Arun District Council
Arun Civic Centre
Maltravers Road
Littlehampton
West Sussex BN17 5LF
Planning & Building Control General
Enquiries
Tel: (01903) 737756 Fax: (01903) 716019
Dx: 57406 Littlehampton
Minicom: 01903 732765
e-mail: planning@arun.gov.uk
website: www.arun.gov.uk/planning
Our Ref: A/48/11/L
Your Ref:

25th March 2011

**Application for Listed Building Consent for conversion of stable & workshop to ancillary accommodation
Pigeon House High Street Angmering**

FOR LISTED BUILDING CASENOTE
PIGEON HOUSE, ANGMERING
SCALE: 1:200 @ A1 DRAWN: SEPT 2010 DWG: PHH-WB/D.01
SITE PLAN & STREET ELEVATION AS PROPOSED
MALCOLM SIMMONDS ARCHITECTS

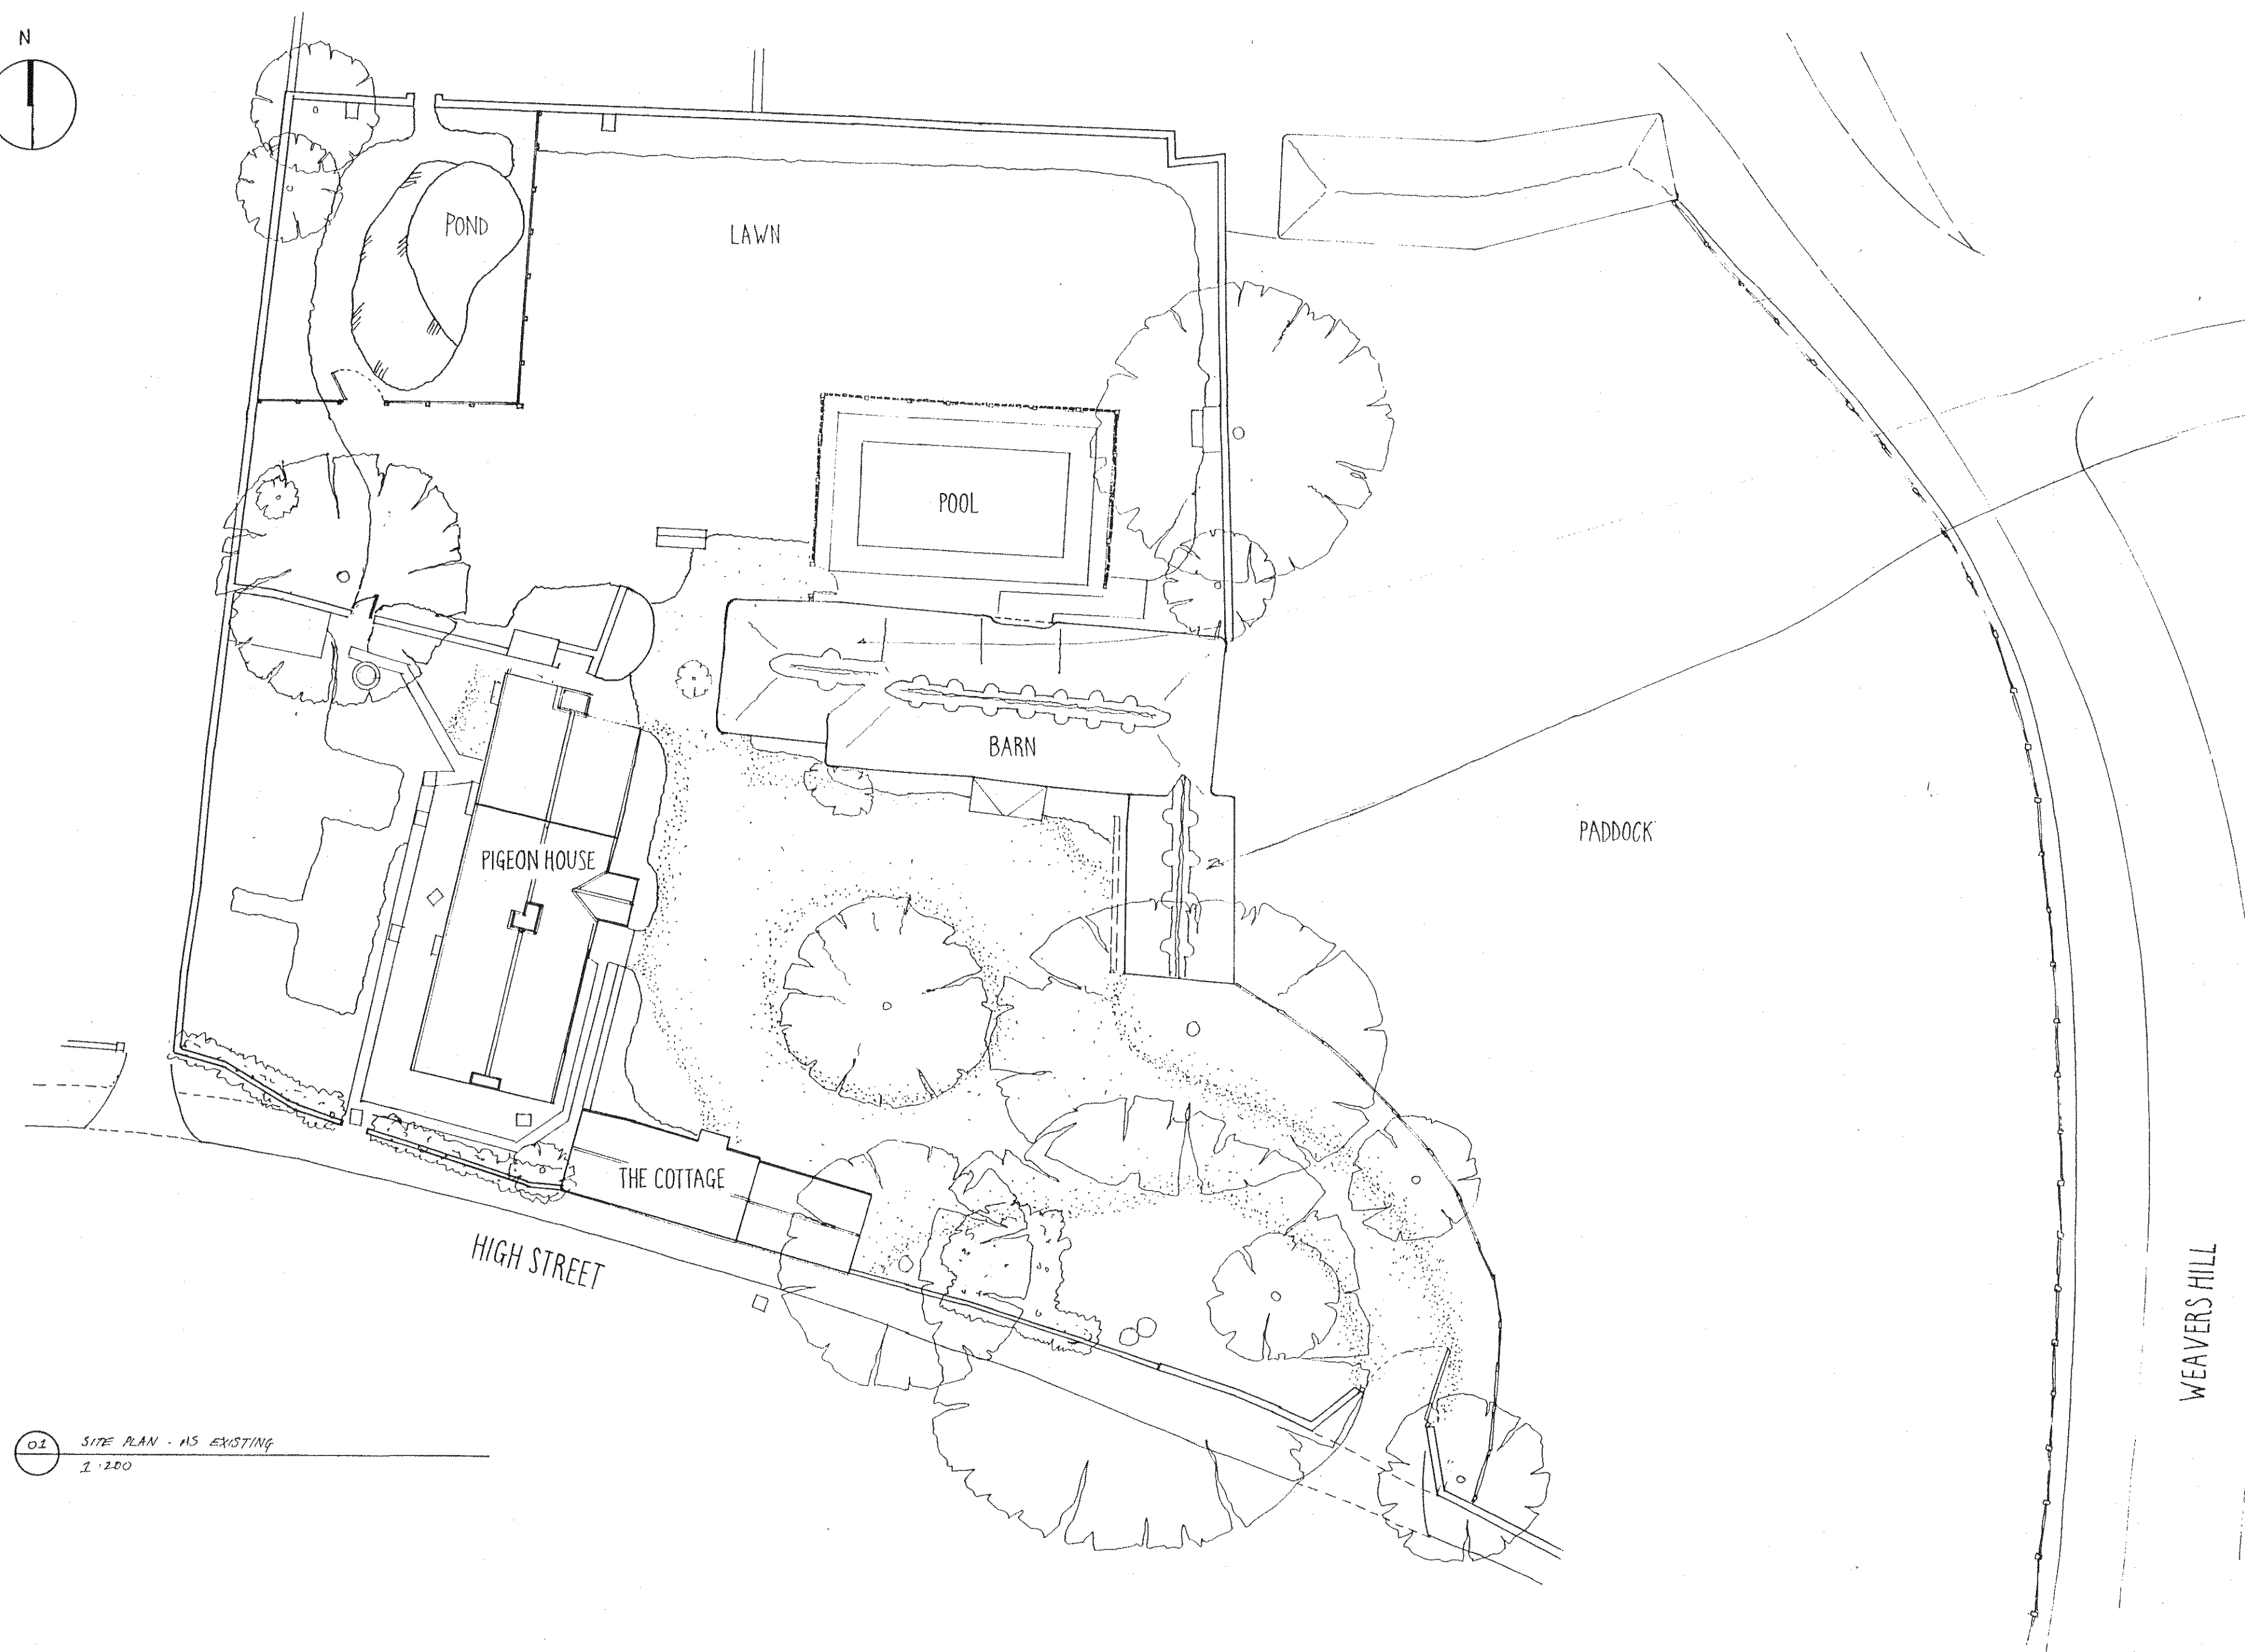
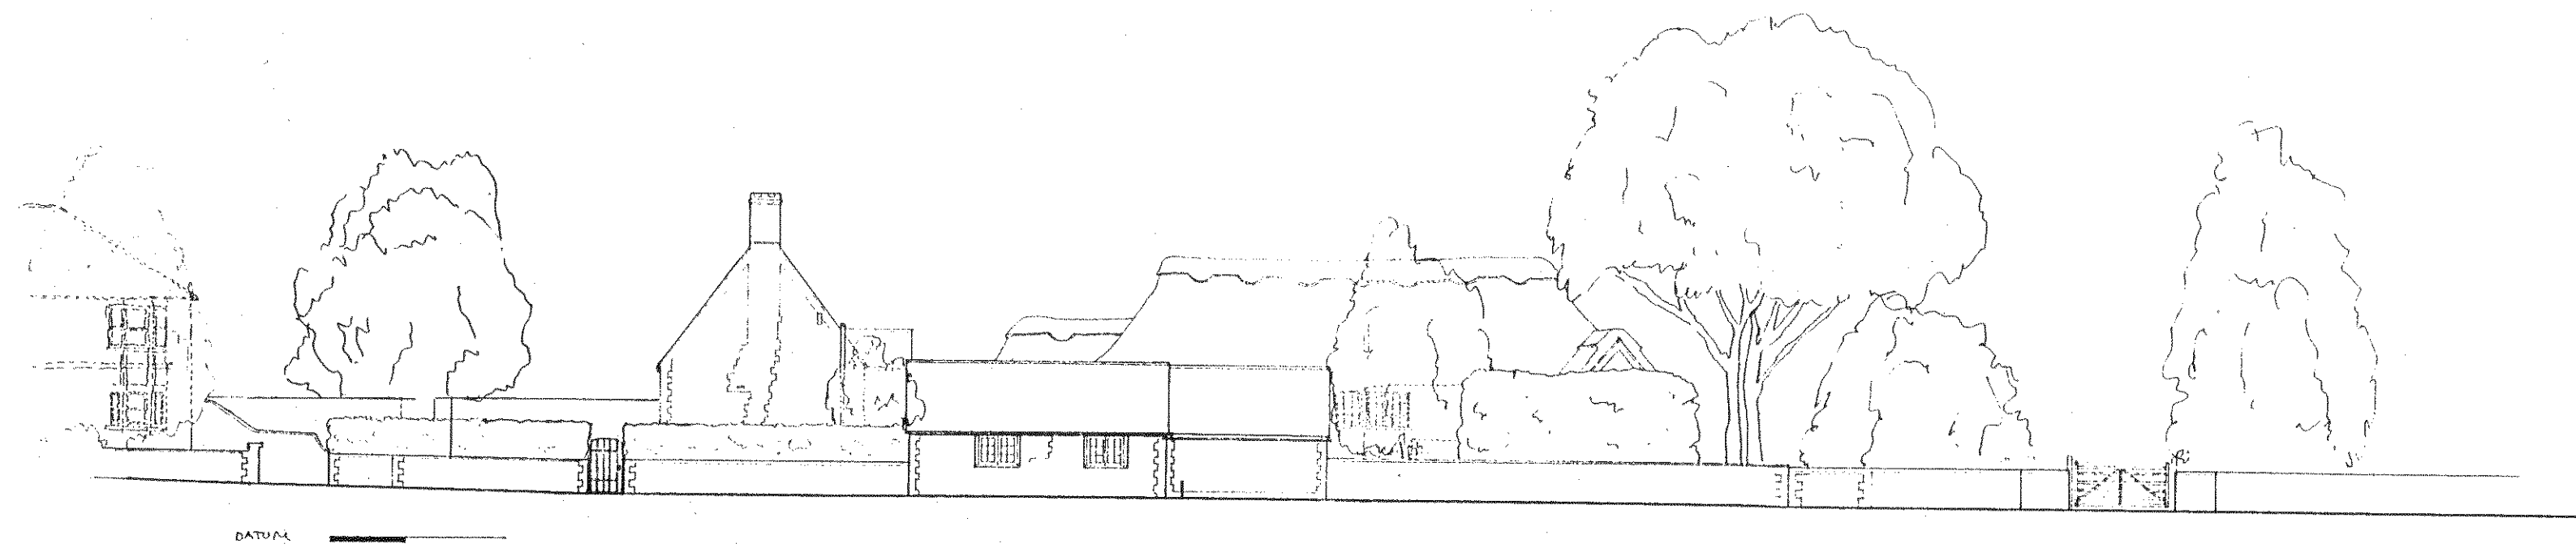
Please submit 3 amended block plans showing the position of the proposed works clearly highlighted
